Our ref: DOC20/884182

**Subject: Glenellen Solar Farm (SSD 9950) - Review of Environmental Impact Statement**

ATTACHMENT A – BCD Assessment Summary for Glenellen Solar Farm Environmental Impact Statement (SSD 9550)

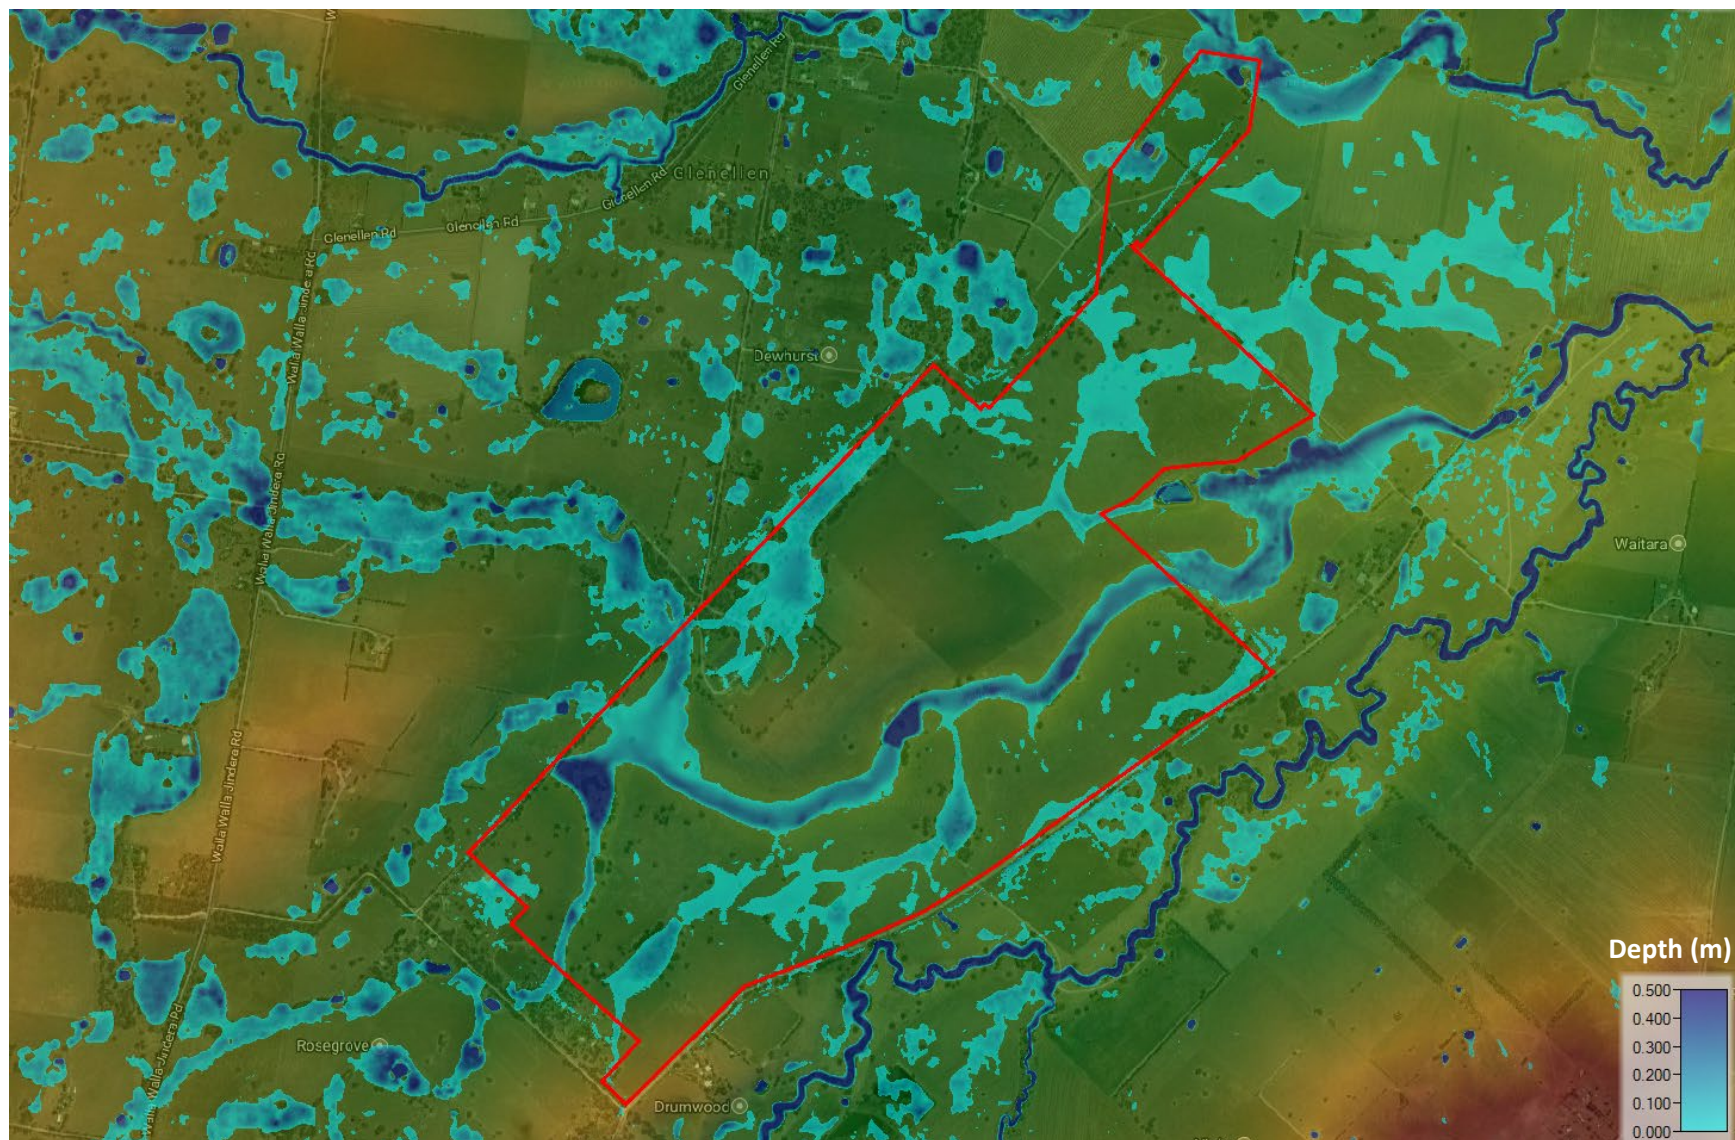
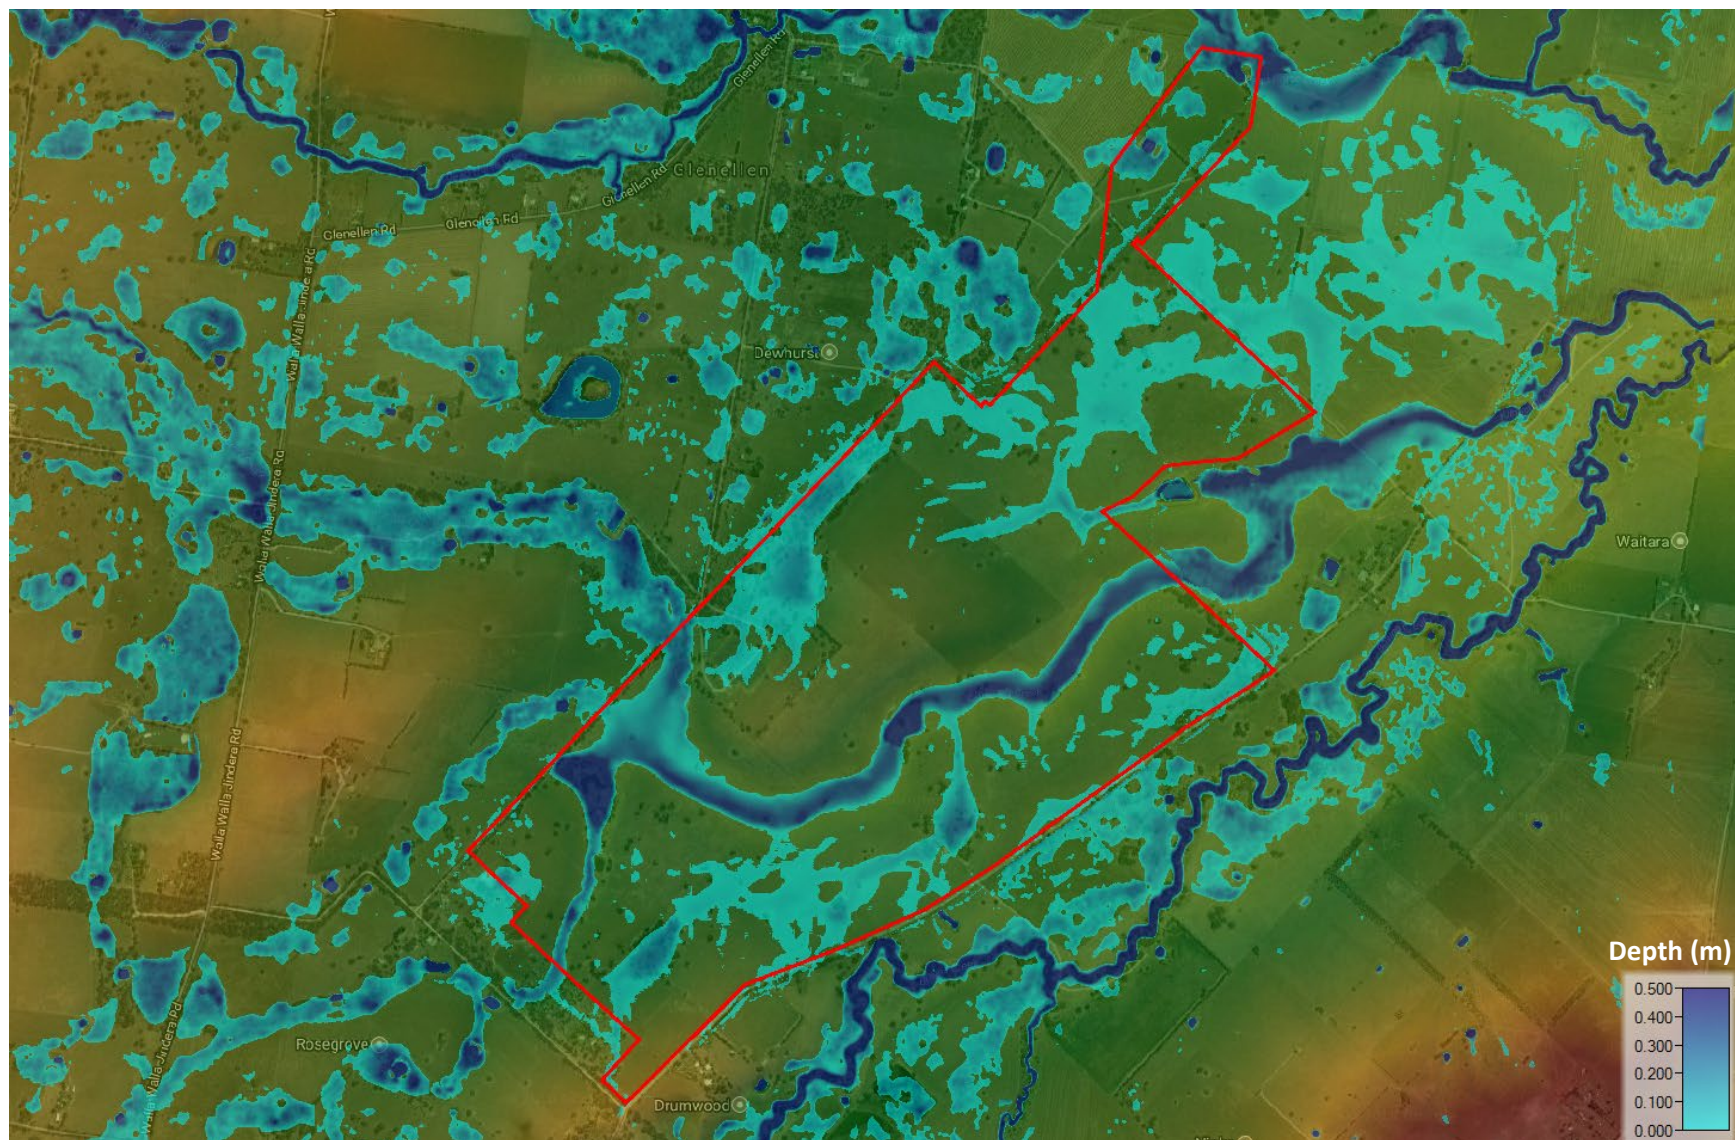
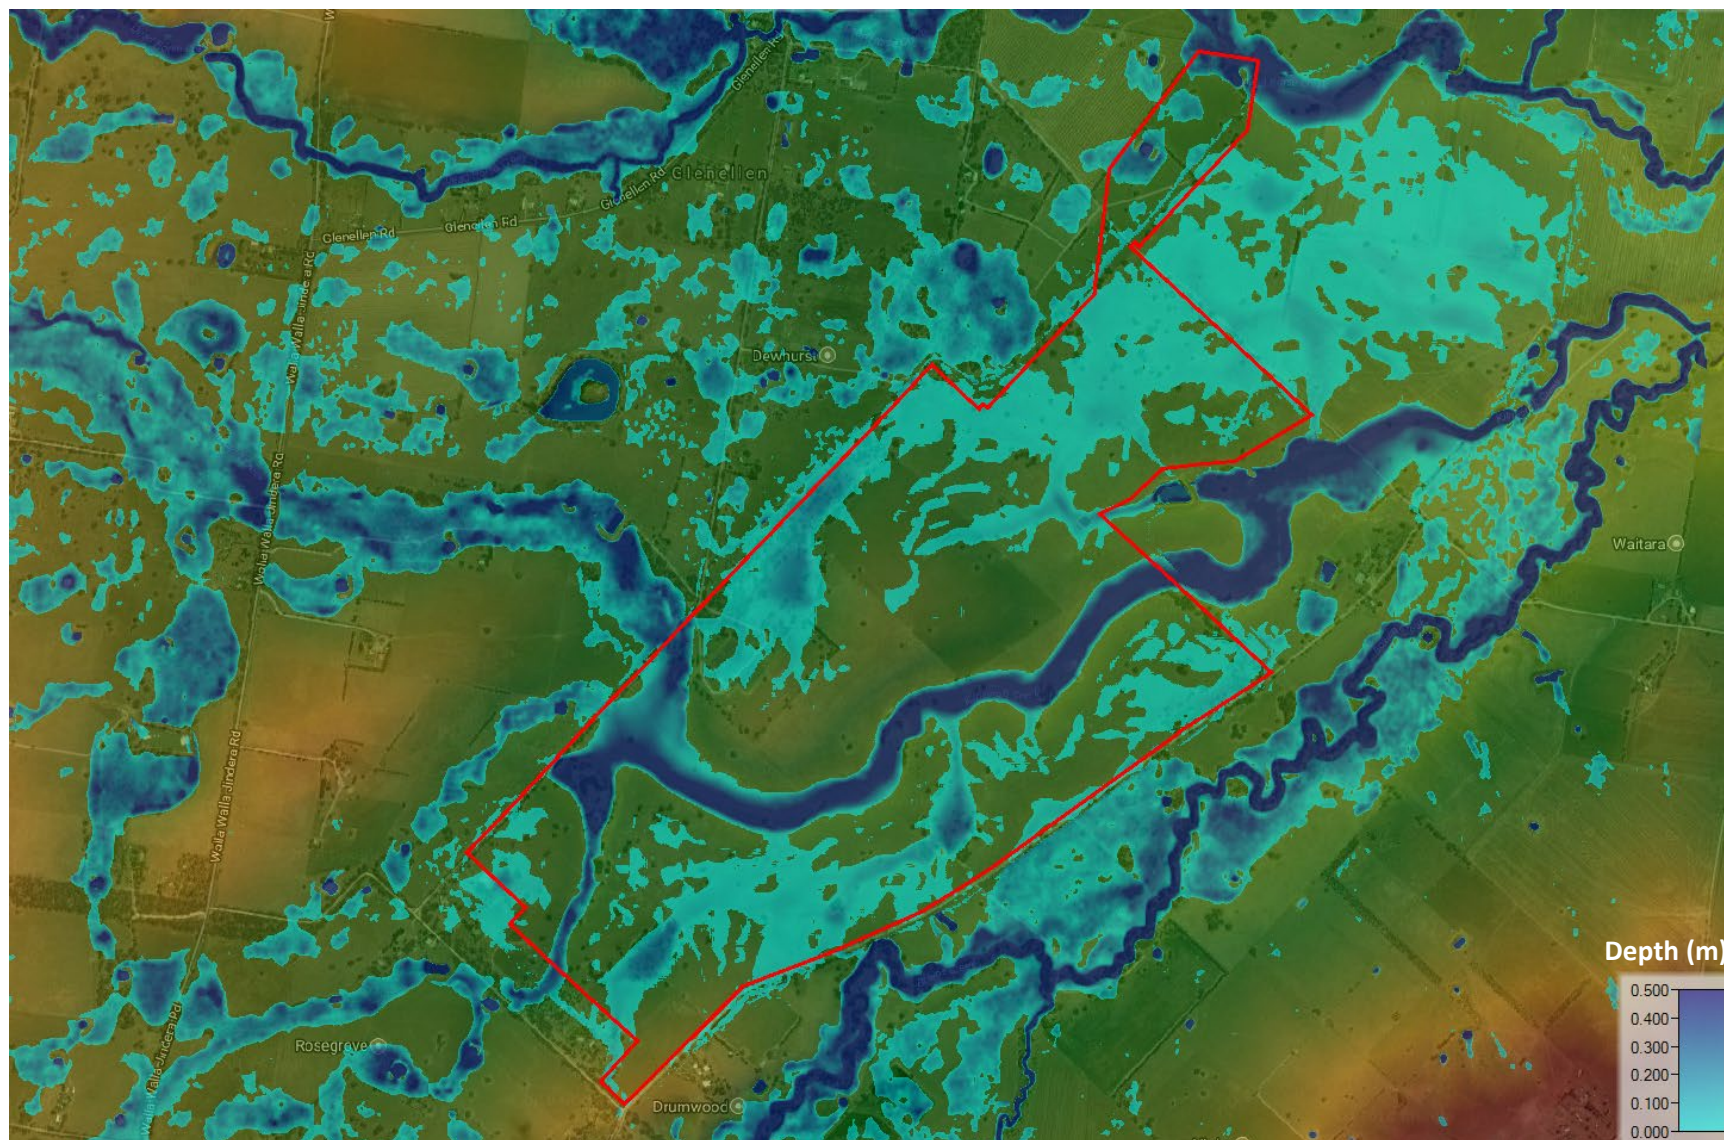
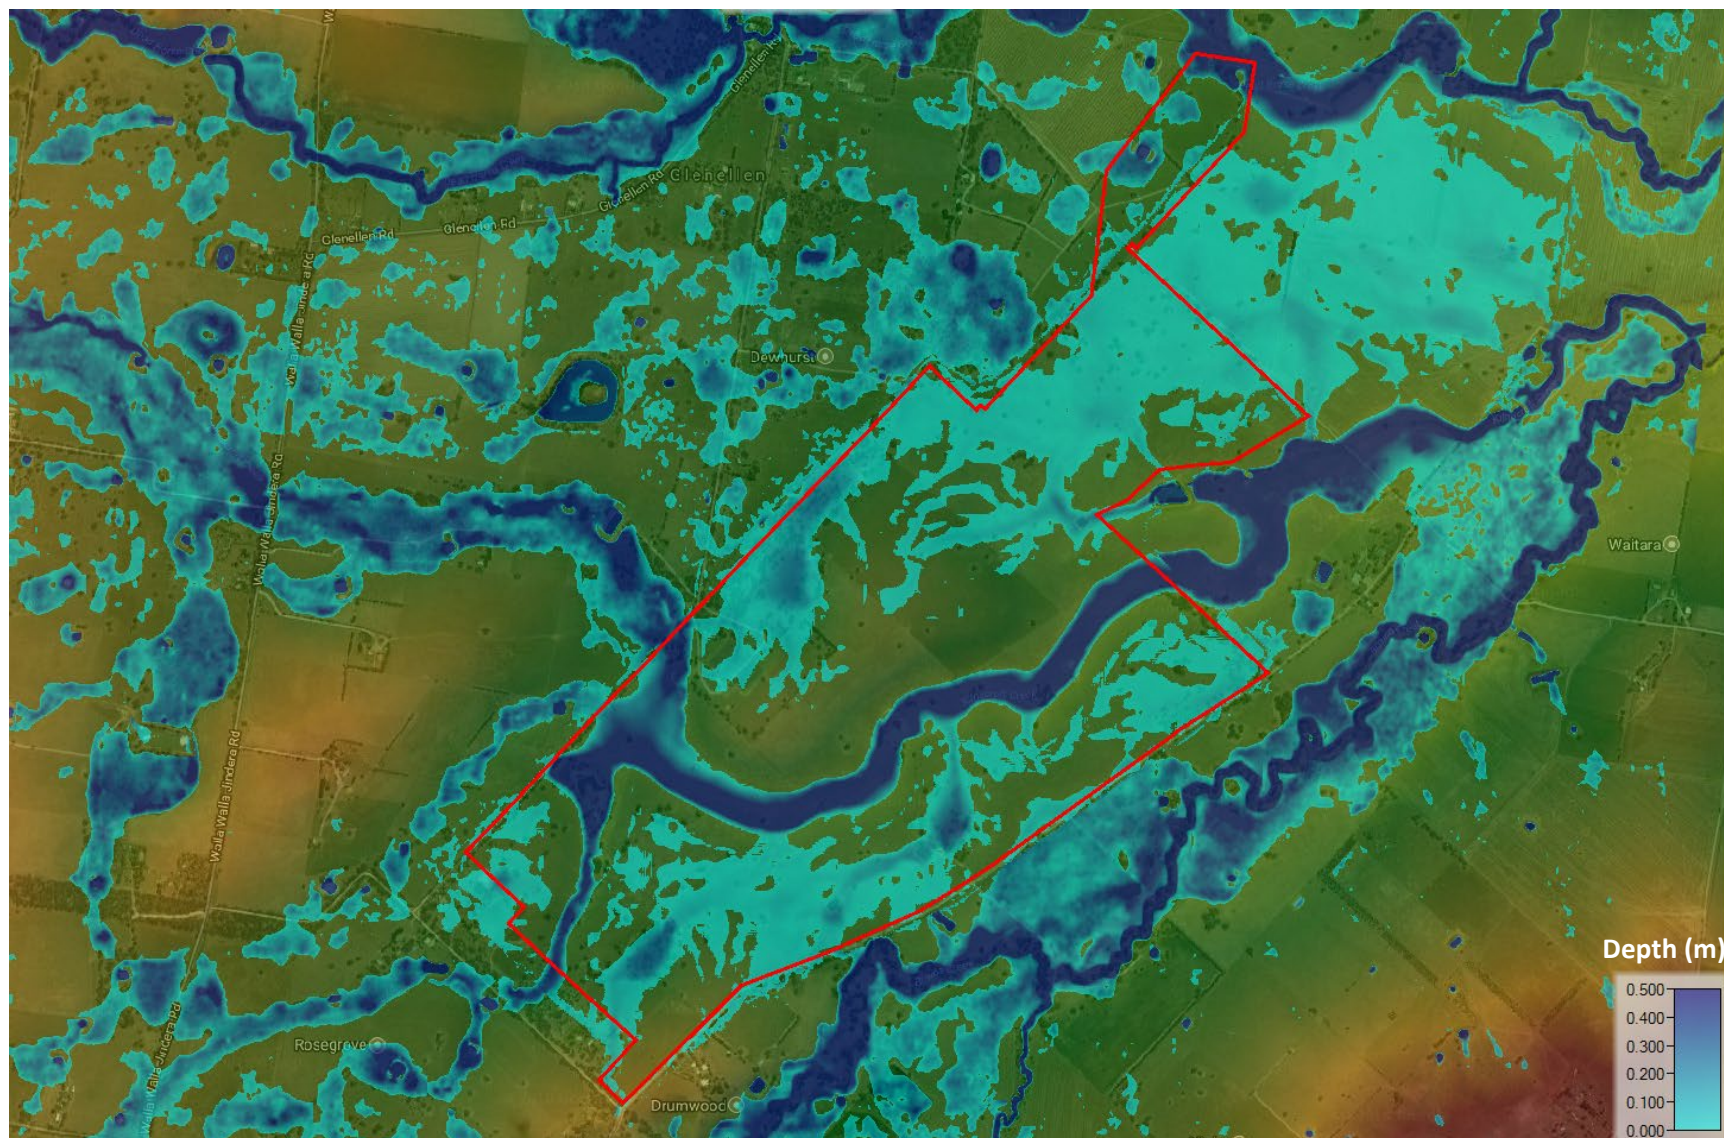
Existing conditions inundation extent maps were generated for 10% Annual Exceedance Probability (AEP), 1% AEP, 0.5 AEP%, 0.2% AEP and 0.1% AEP (1 in ~10-year, 100-year, 200-year, 500-year and 1000-year Annual Recurrence Interval (ARI), respectively).

The flood mapping shows significant flow paths crossing the site that develop during local intense rainfall events in all design events.

No flood mapping has been developed that show the flood hazards or hydraulic categories (floodways, flood storage and flood fringe areas) across the site. This is needed for the appropriate locating of infrastructure.

1. The proponent must be required to complete additional flood modelling in the detailed design phase to define the flood hazards and hydraulic categories across the development site prior to finalising the location of critical infrastructure.
